EYECARE MEDICAL GROUP
PHASE 2 ADDITION AND RENOVATION
ADDENDUM NO. 3
JULY 23, 2013

This Addendum modifies, amends and supplements designated parts of the Contract Documents, Project Manual and Drawings for E.M.G. - Phase 2 - Addition and Renovation and is hereby made a part thereof by reference and shall be as binding as though inserted in its entirety in the locations specified herein. It shall be the responsibility of the Contractor to notify all Subcontractors and Suppliers he proposes to use for the various parts of the work of any changes or modifications contained in this Addendum.

A002

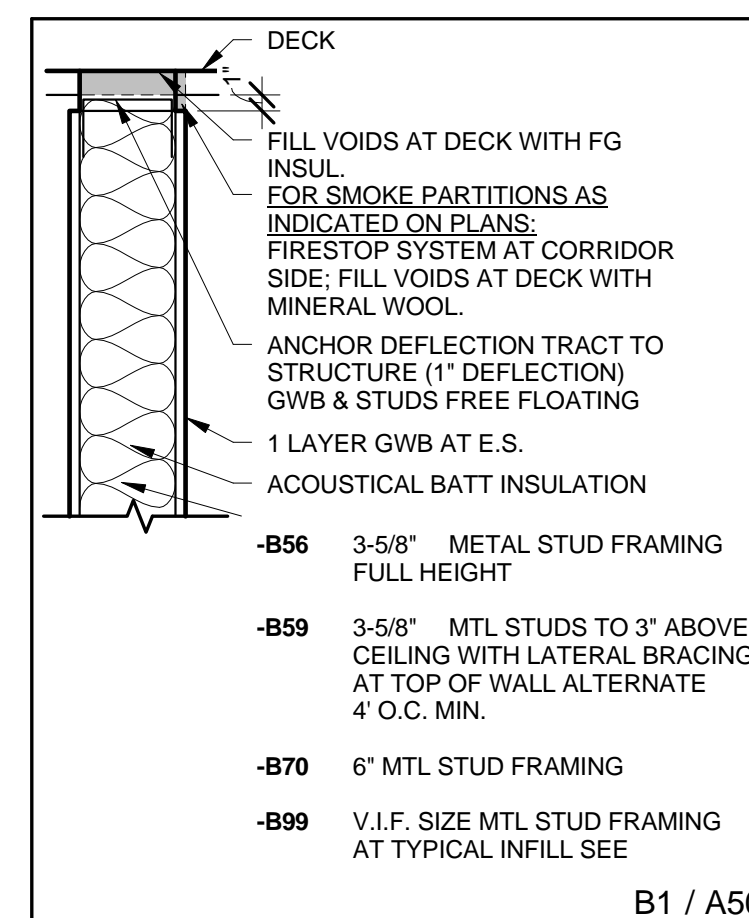
1. Sheet A002 - DELETE text reading "VAPOR RETARDER" shown on the Single-Ply Membrane Roofing System on Concrete Slab.
2. Sheet A202 – DELETE cabinets in Post Op BI09 (6 stations), as shown on elevations BI and CI.
3. Sheet A501 – REPLACE detail D3 with the attached SKA-5.
4. Sheet A503 – REPLACE detail BI with the attached SKA-4, indicating a typical soldier course in the exterior walls (with the exception of the quoin corners).
5. Sheet A600 - CHANGE, Door and Frame Schedule, Door N^o AI17 (Gas Room) width to be 3'-6".
6. Sheet A600 – CHANGE aluminum storefront type W1 to be 3'-4" above floor finish, to align appropriately with brick coursing.
